**Jean Fraser - 79 Walnut Street - Munjoy Heights**

**TO:** Jean Fraser, Planner  
**FROM:** David Senus, P.E.  
**DATE:** December 6, 2013  
**RE:** Munjoy Heights, Final Level III Site Plan Application

Woodard & Curran has reviewed the Final Level III Site Plan Application for the proposed infill residential development located at 79 Walnut Street in Portland, Maine. The project consists of the development of 29 townhouse style residences.

RAIN GARDEN OR BIORETENTION CELL DETAIL
NOT TO SCALE

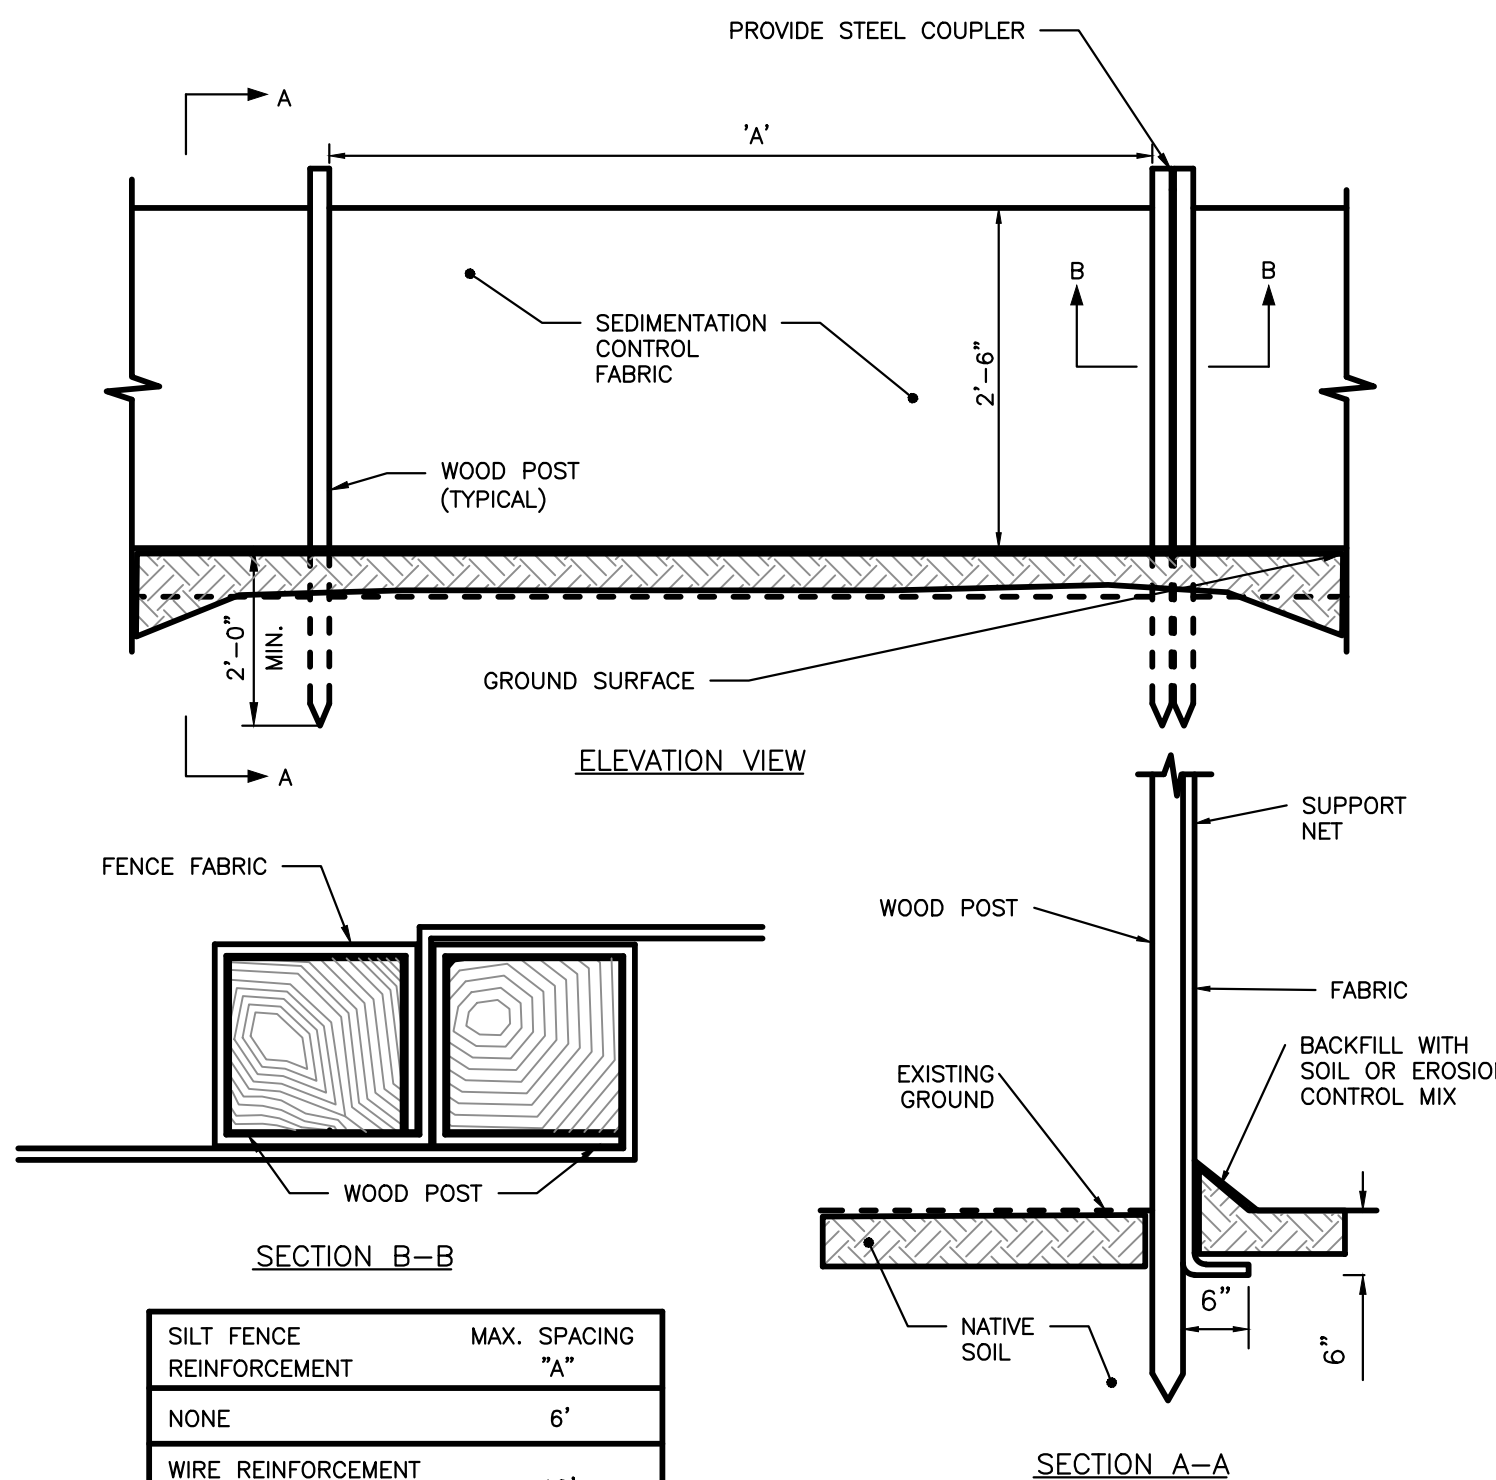
- 16) Comment adequately addressed.
- 17) The details provided for the underdrained soil filters (rain gardens) on C-42 do not provide sufficient detail at the edges of the system, where the in-slope meets the driveway/walkway pavers. The in-slope should be designed with measures to avoid erosion and under-mining of the adjacent pavers. As noted in Comment #3, the soil filters are not currently designed with an impermeable liner below the underdrain. The project geotechnical engineer should review the design to ensure that the introduction of surface water to the subsurface soils will not create geotechnical concerns.

DRAWING NO. C-30

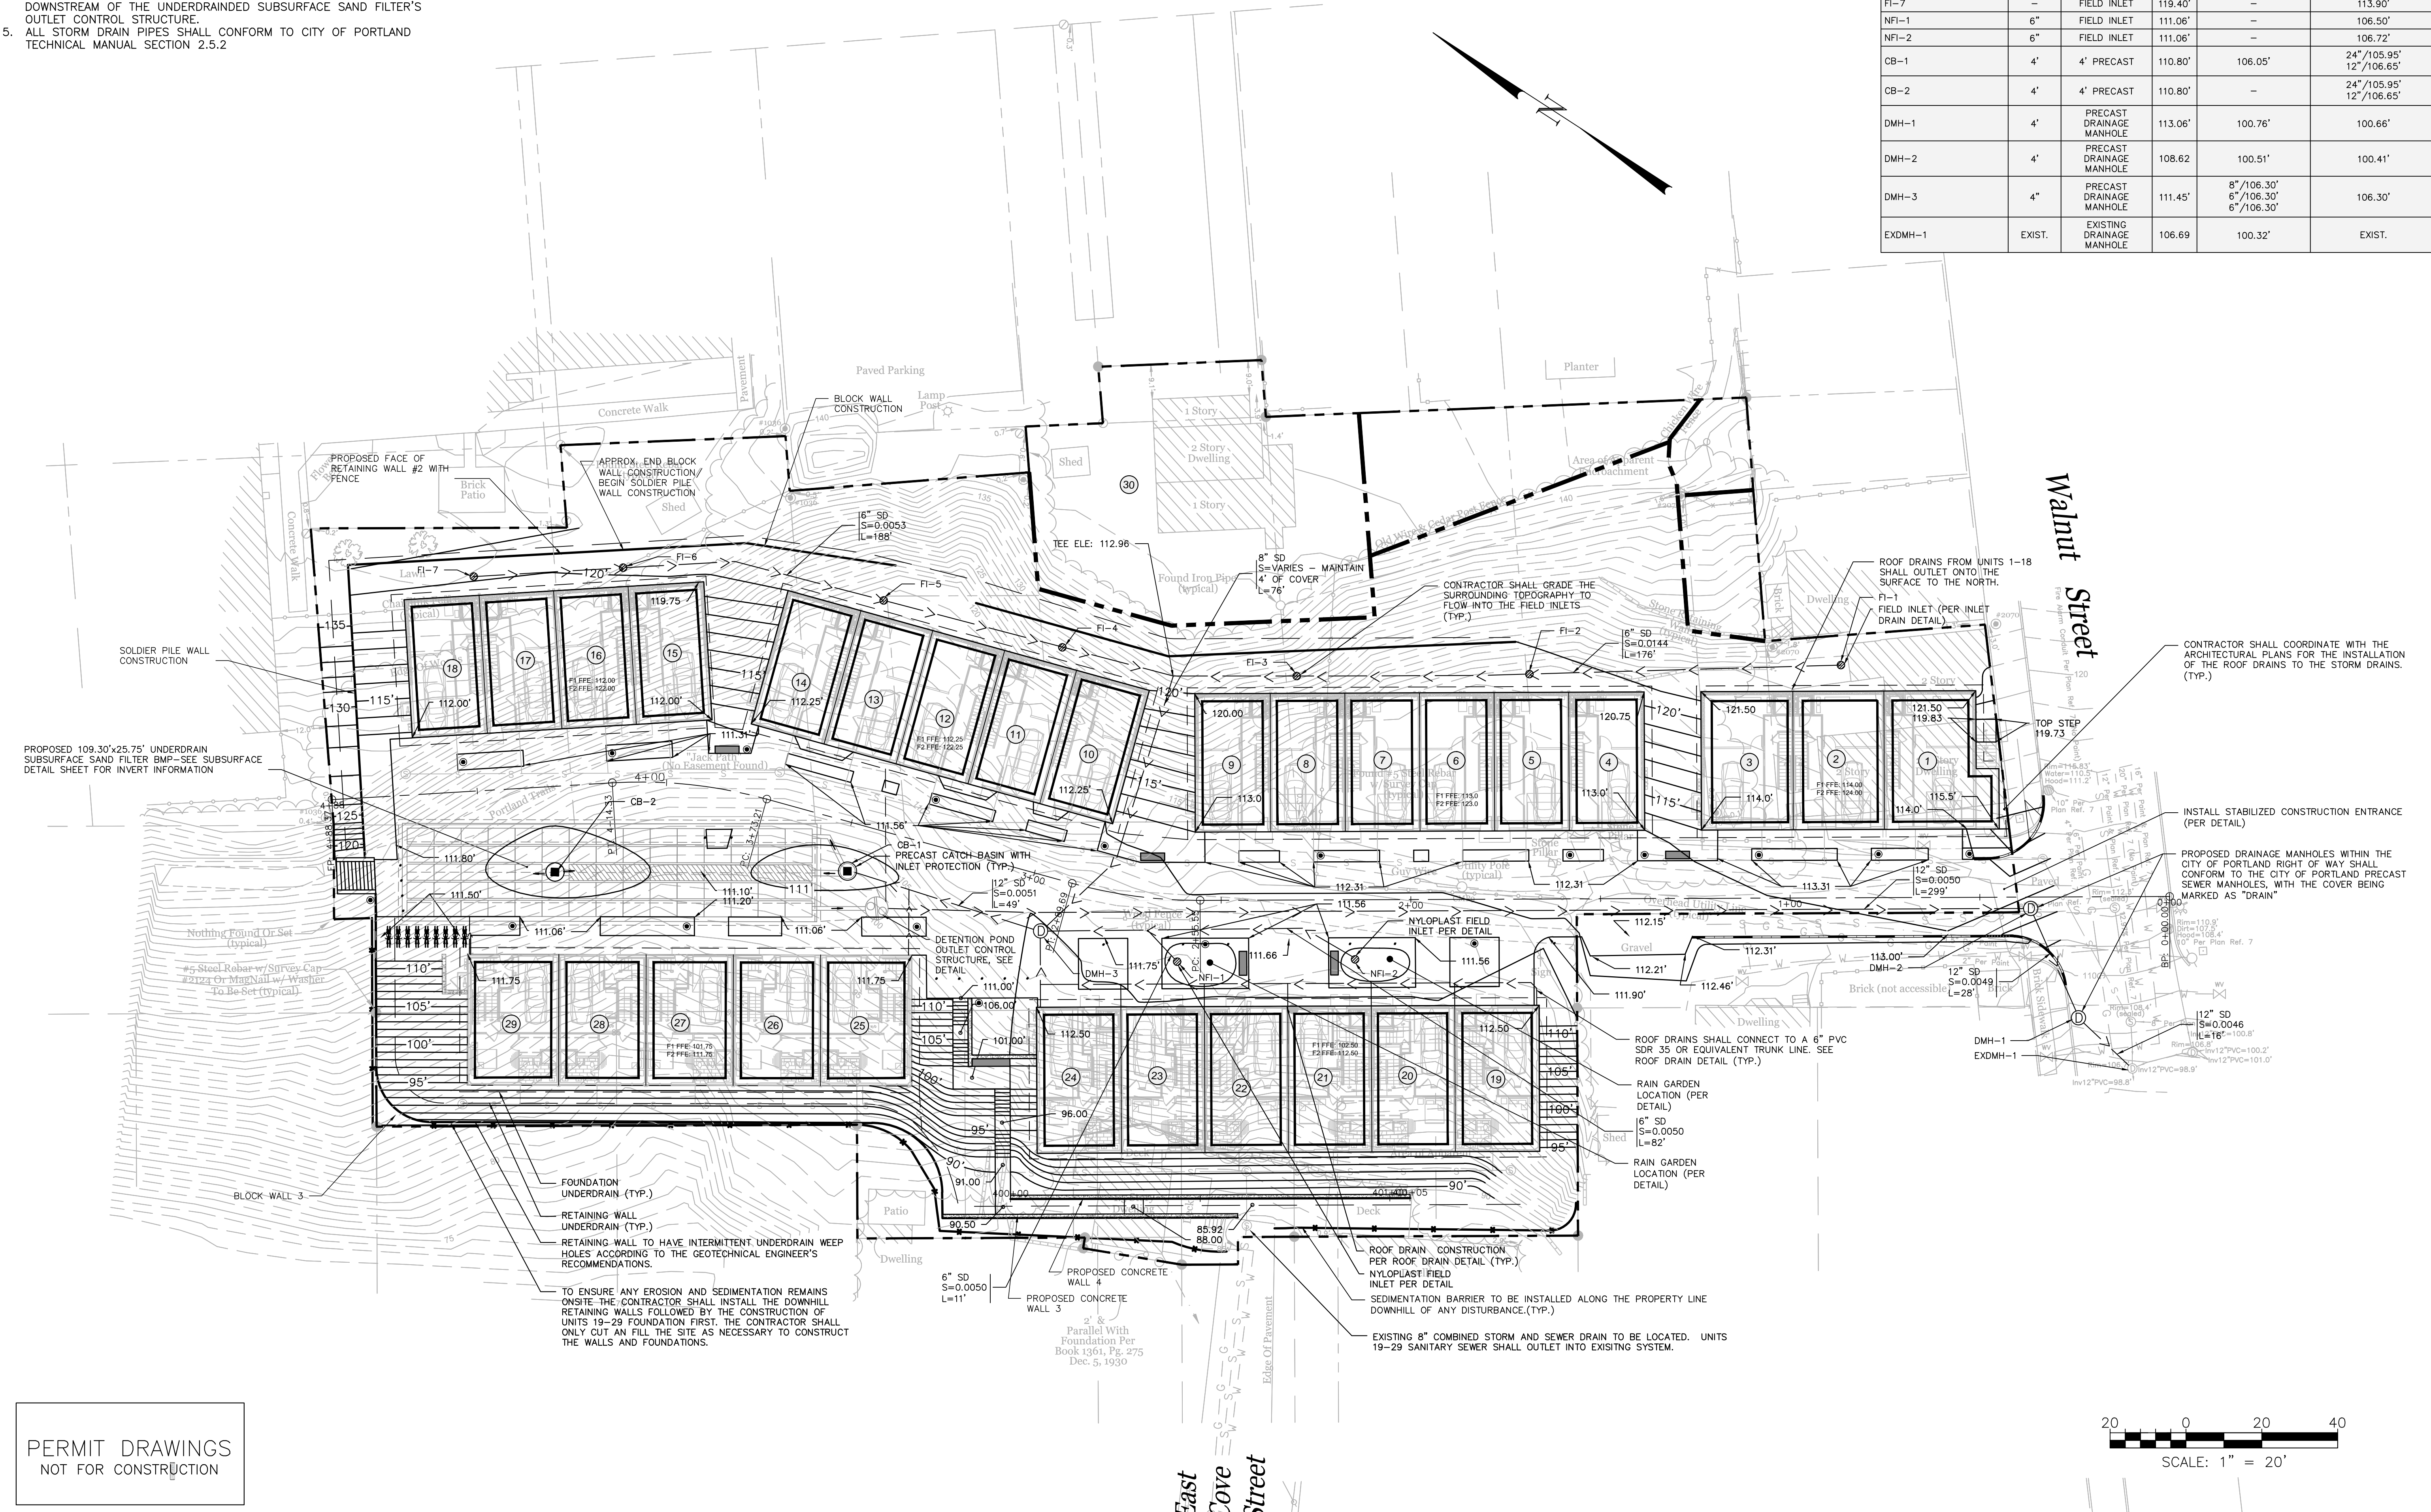
- 1) a), b) & c) (i.)(ii.)(iii.) – Comments adequately addressed.
- 2) a), b) & c) – Comments adequately addressed.
  - d) Sheet C-30: The access/diversion structure labeled CB-1 has two outlets, a 12" pipe and a 24" pipe. The 24" pipe connects to the Isolator Row, whereas the 12" pipe appears to connect to an adjacent standard chamber. Please clarify the intent of 12" pipe, along with the invert elevation. Because the Isolator Row is intended to remove sediment and debris from the stormwater flow, we would not anticipate that the 12" pipe invert elevation would be set the same as the 24" pipe invert elevation. If the 12" pipe is acting as a high-flow outlet, we would anticipate that the invert elevation of this pipe would be set higher than the 24" pipe.

- 18) The Applicant has noted that a revised C-30 drawing will be provided to address the previous review comment; we will review upon receiving the revised C-30 plan.

DRAWING NO. **C-31**

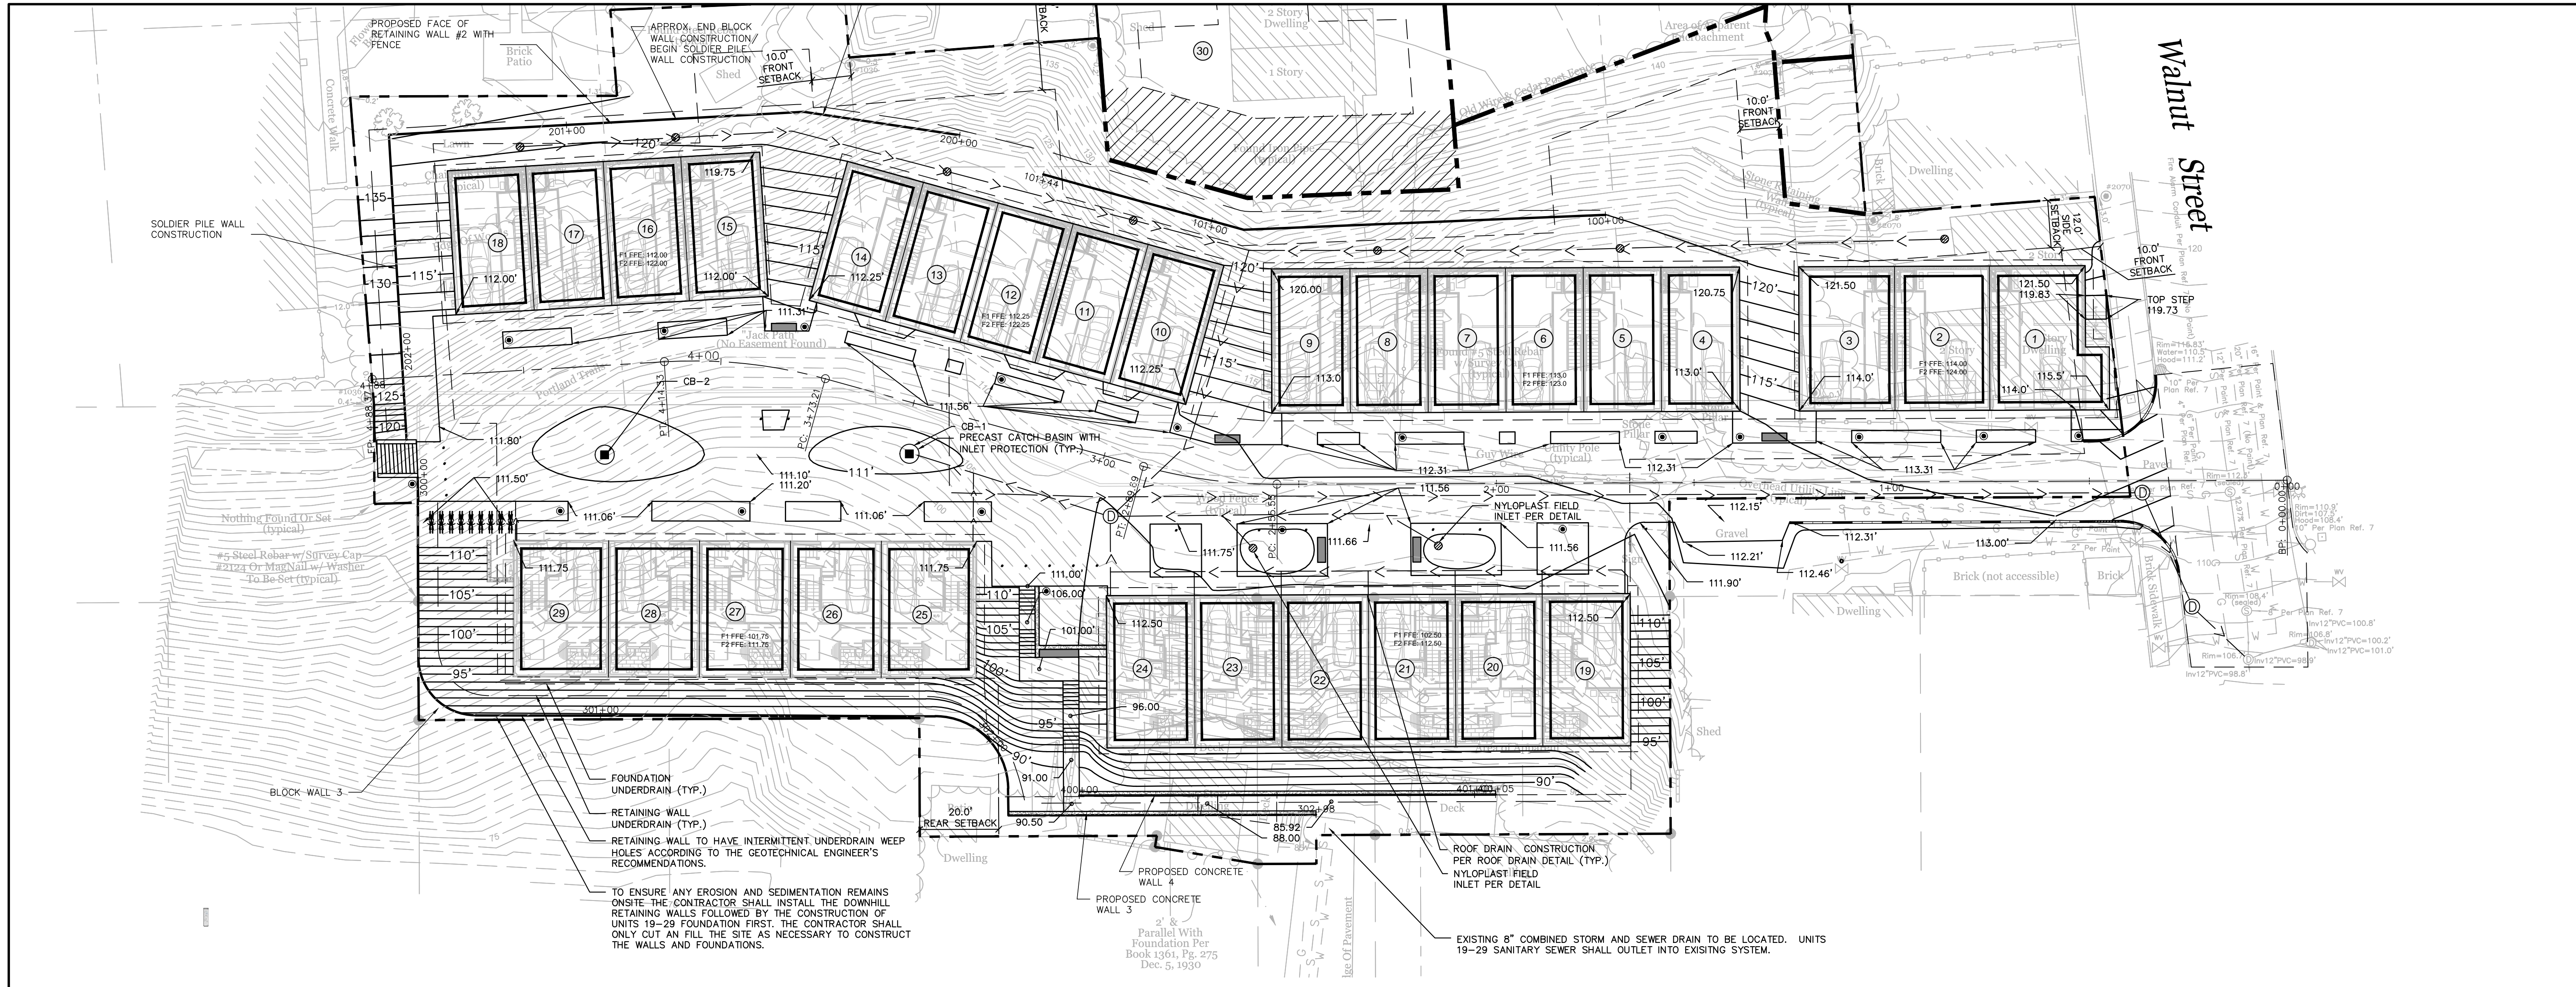
- 20) Comment adequately addressed.
- 21) Comment adequately addressed.
- 22) Comment adequately addressed.
- 23) On Sheet C-32 & C-33 the Applicant has noted that Summit Engineering Services in coordination with Structural Integrity Consulting Engineers, Inc., shall provide the retaining wall design, global stability analysis, and the design of the temporary soil restraint measures, as required. We recommend a condition of approval stating that the retaining wall designs be completed and submitted to the City as part of the Building Permit process prior to construction, and that it be stamped by a professional engineer.
